Application for Planning Permission for Works or Extension to a Dwelling

Development: The proposal is for the removal of the existing domestic garden shed and its replacement with a new shed within the residential rear garden. The replacement shed will be used solely for the enjoyment of the dwelling house, including general garden storage.

Location: Ashley The Roundway Rustington BN16 2BW

I regret that I am unable to accept your documents as a valid application until the following item(s) have been received or resolved :-

LOCATION PLAN
Rear garden project
1:1250 at A2

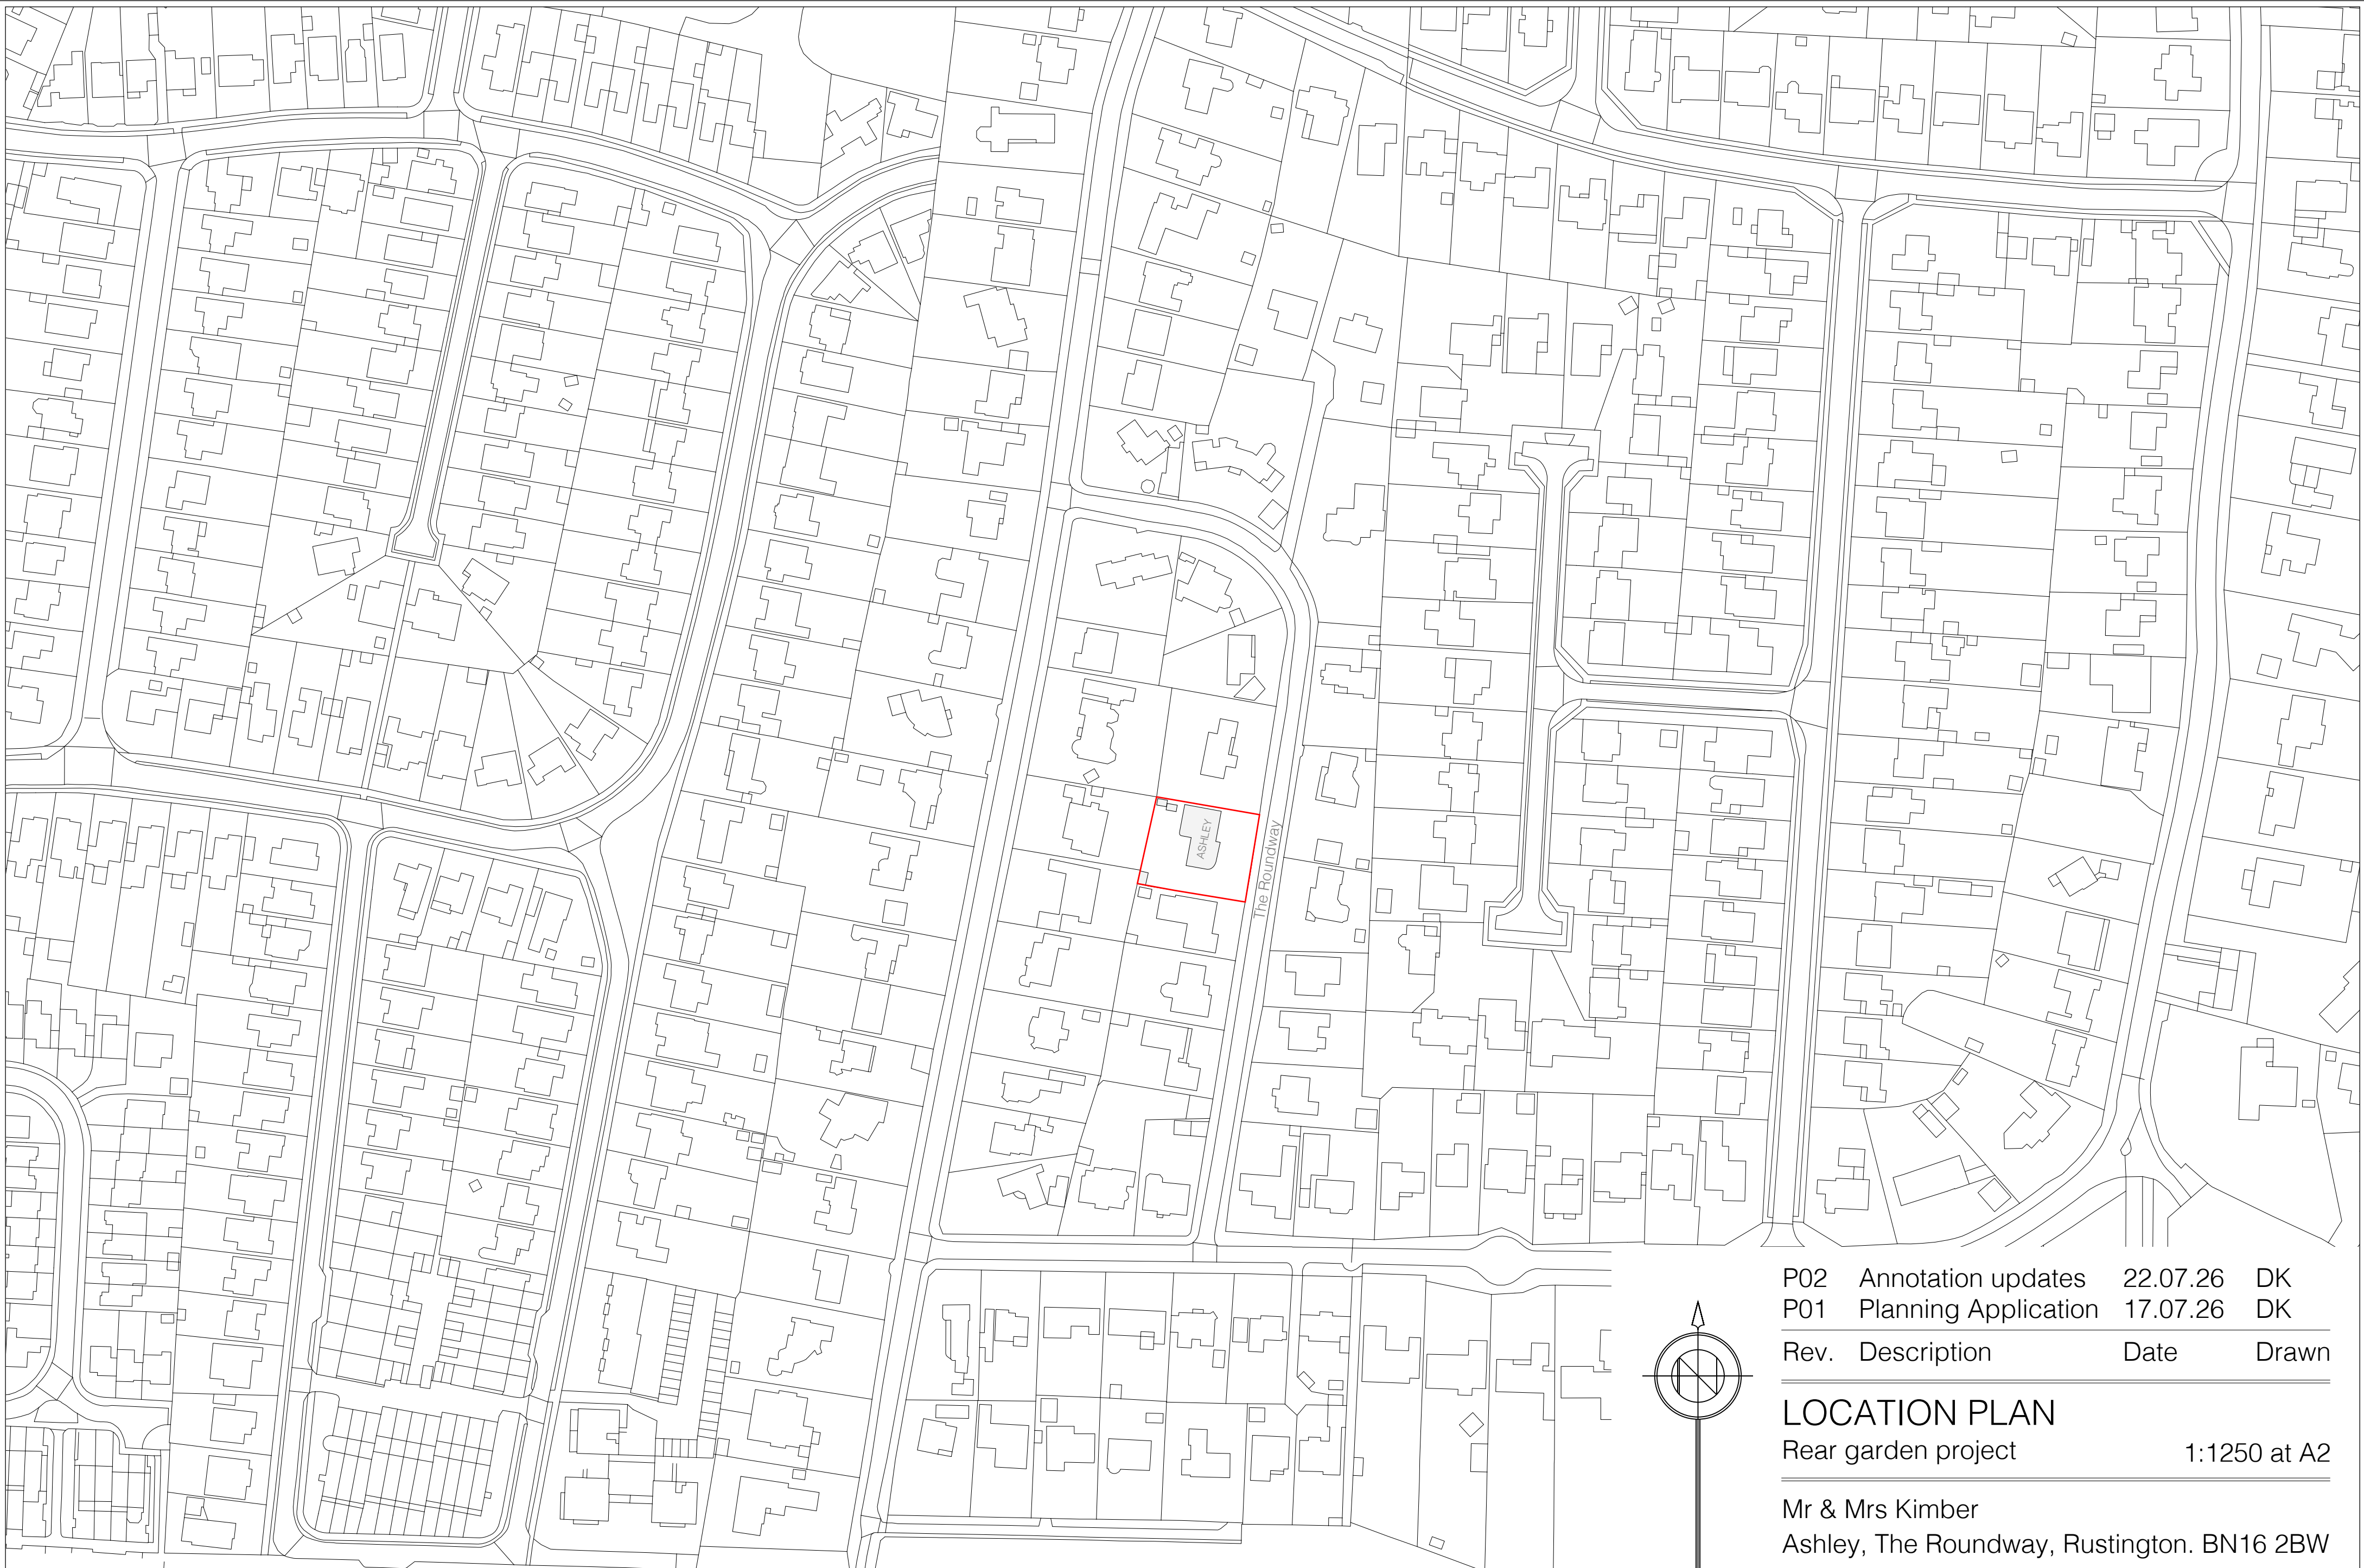
The location plan (001) existing shed dimensions are inconsistent with the with the existing site plan (003) existing shed dimensions.

A scalebar is required alongside the provided scale in the location plan (001).

Location plans (001) require the the site boundary is solidly outlined in red.

BLOCK PLAN
Rear garden project1:500 at A2

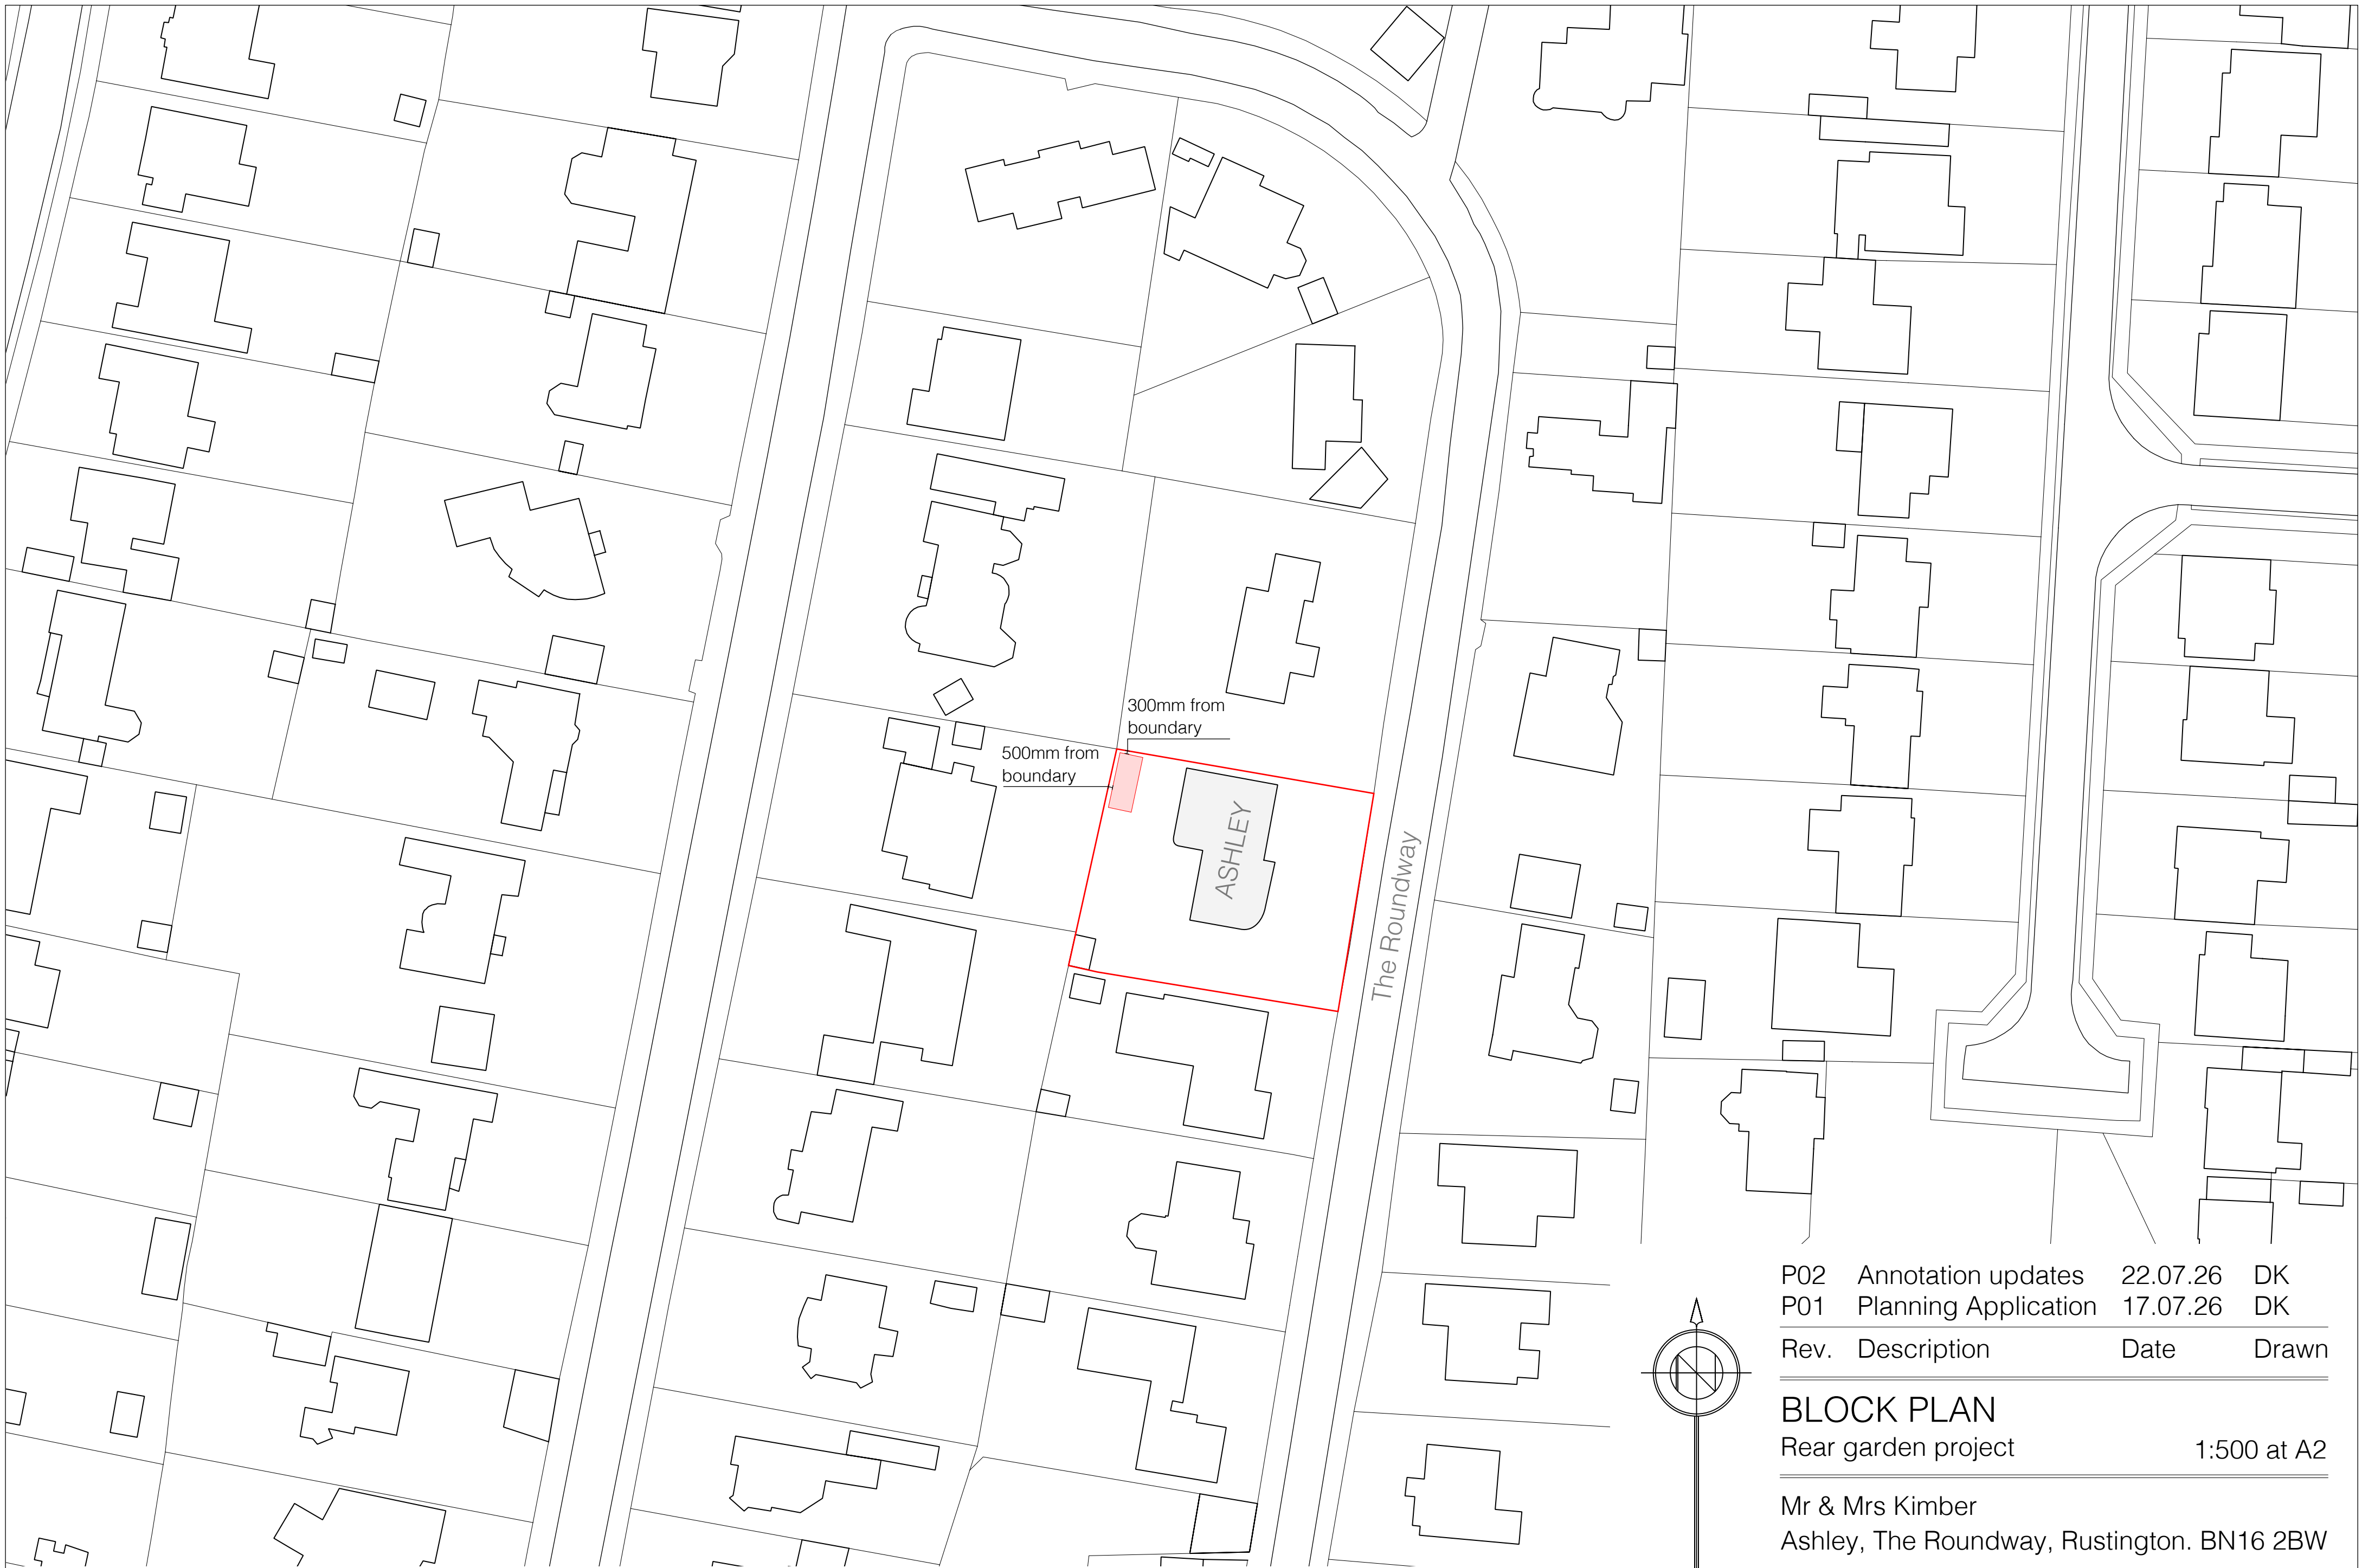
Dimensions from the proposed installation to the site boundary are required within block plans (002). A scalebar is also required for this plan.

The dimensions of the proposed shed within the block plan (002) are inconsistent with the proposed site plan (004) shed dimensions.

Please ensure the proposed shed dimensions are consistent across all plans.

PROPOSED SITE PLAN
Rear garden project1:50 at A2

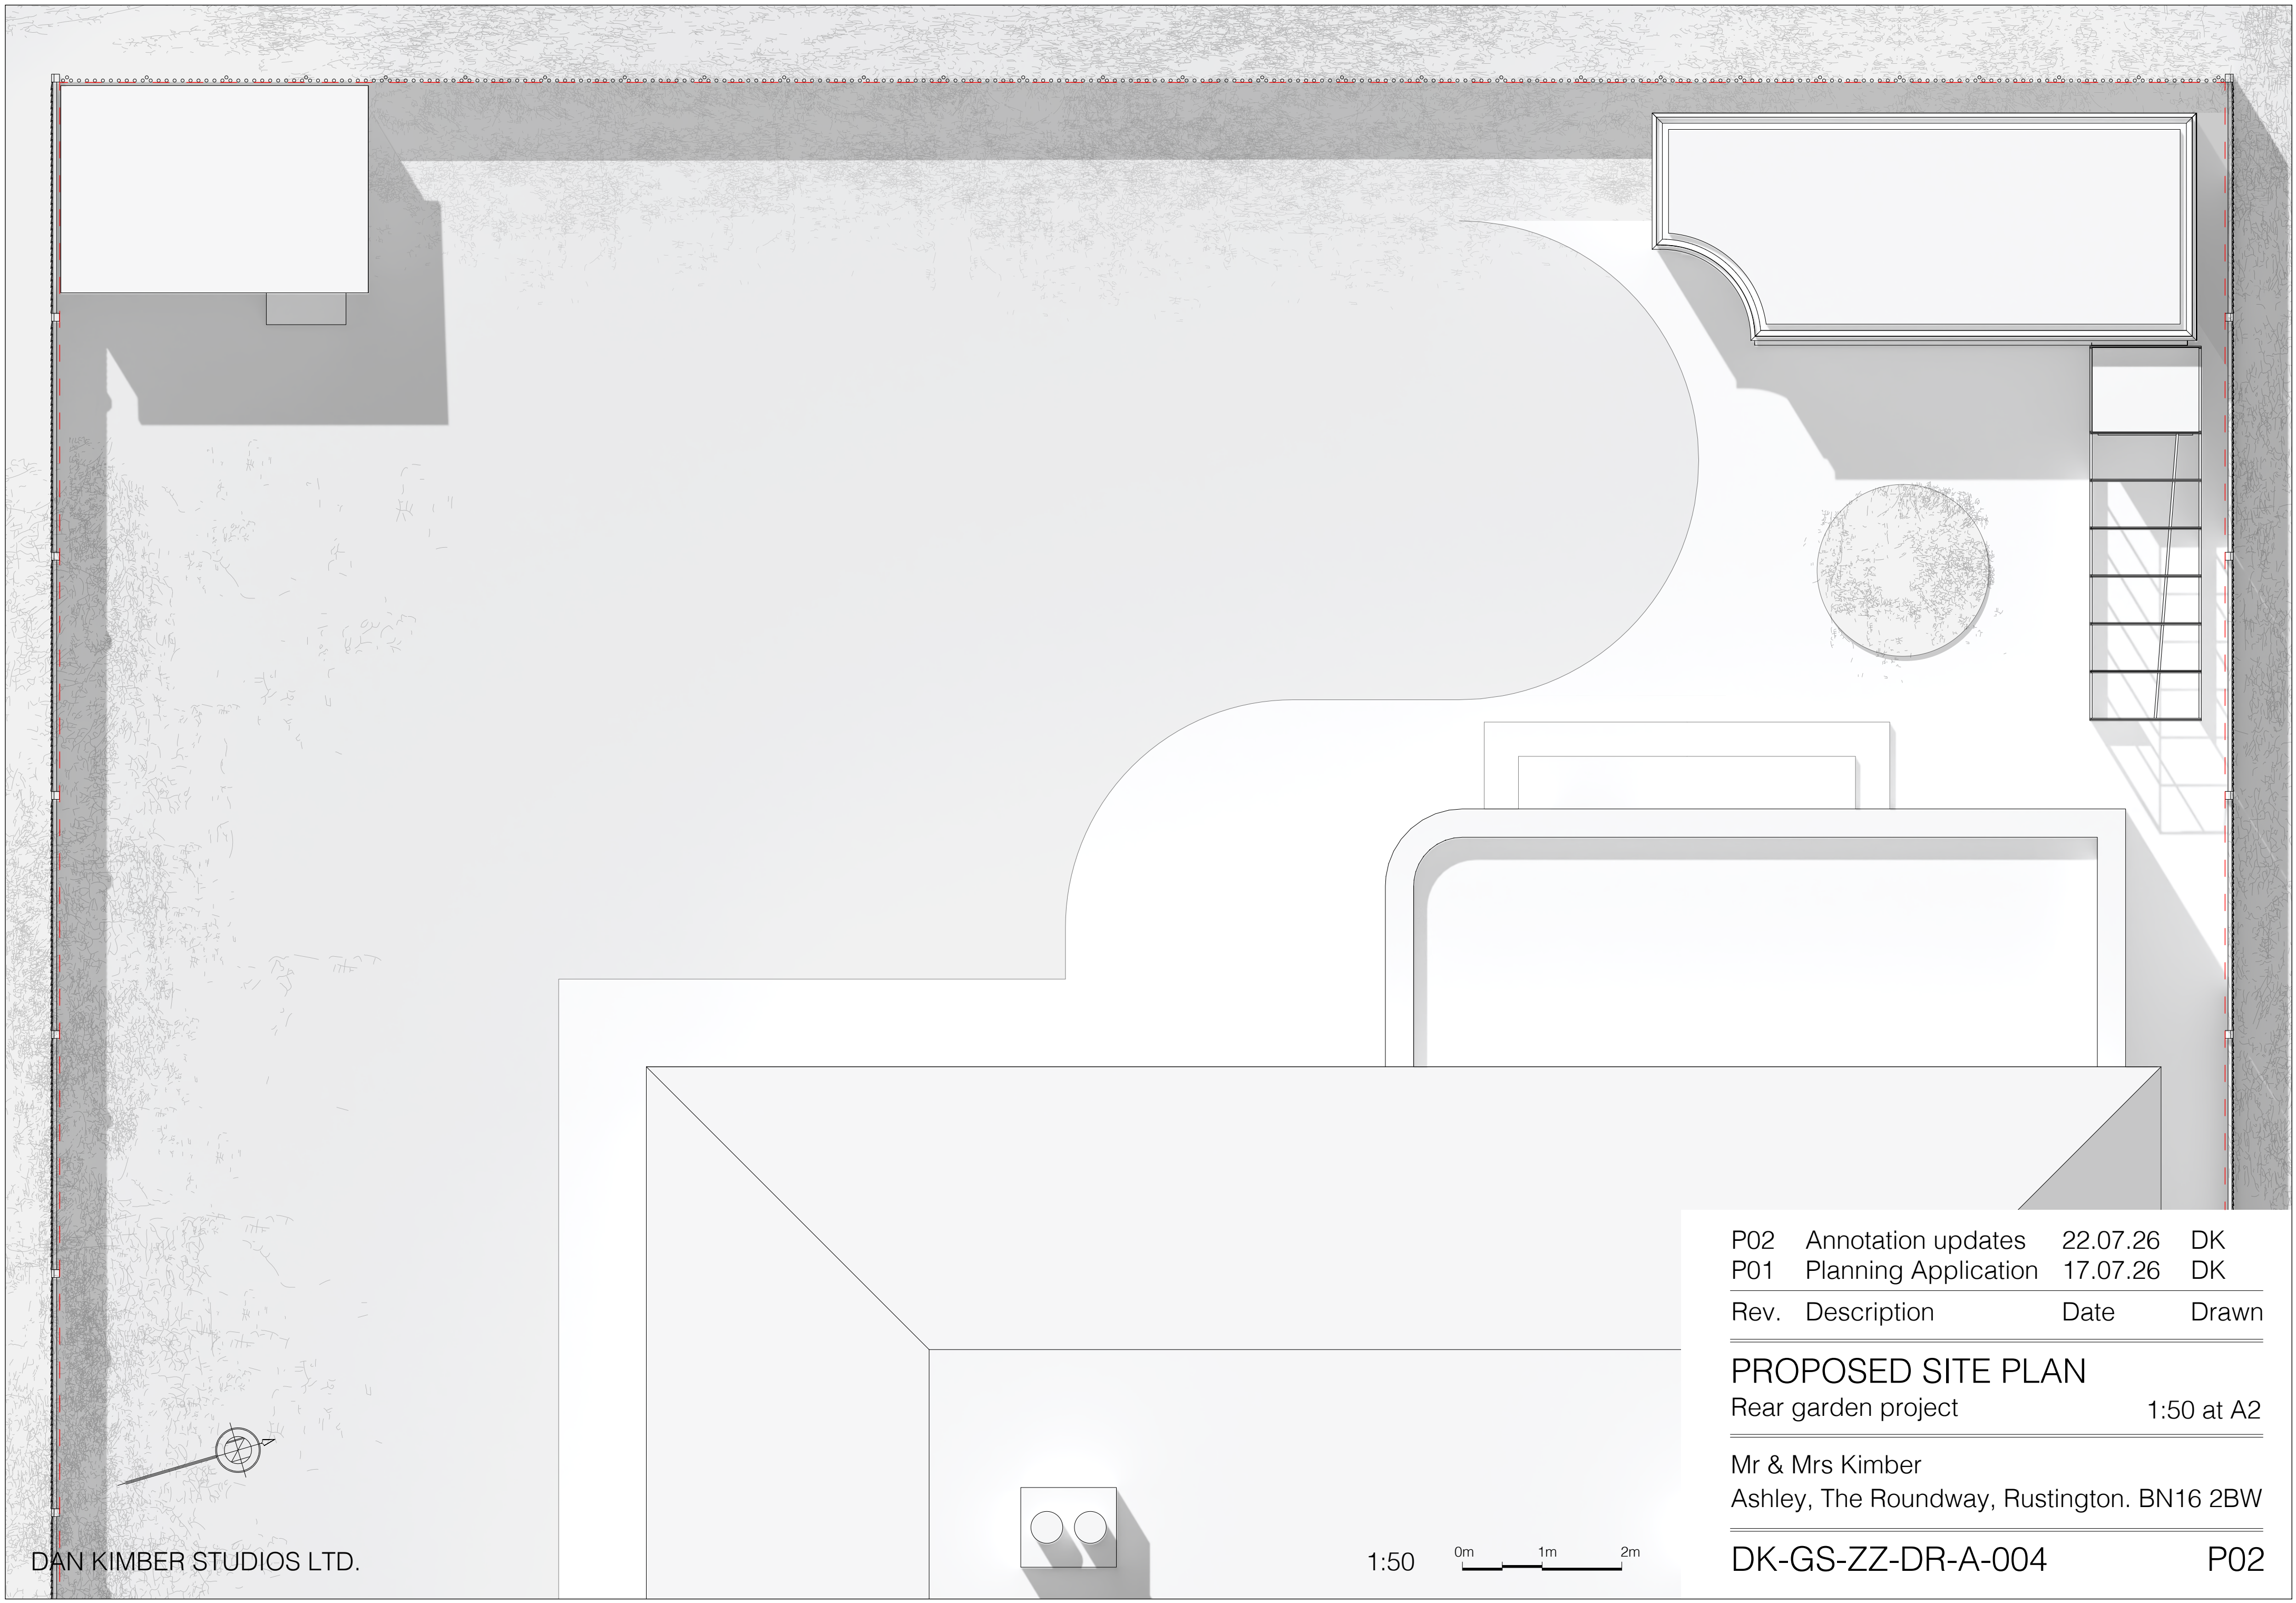
The proposed site plan (004) requires a scalebar alongside the provided scales.
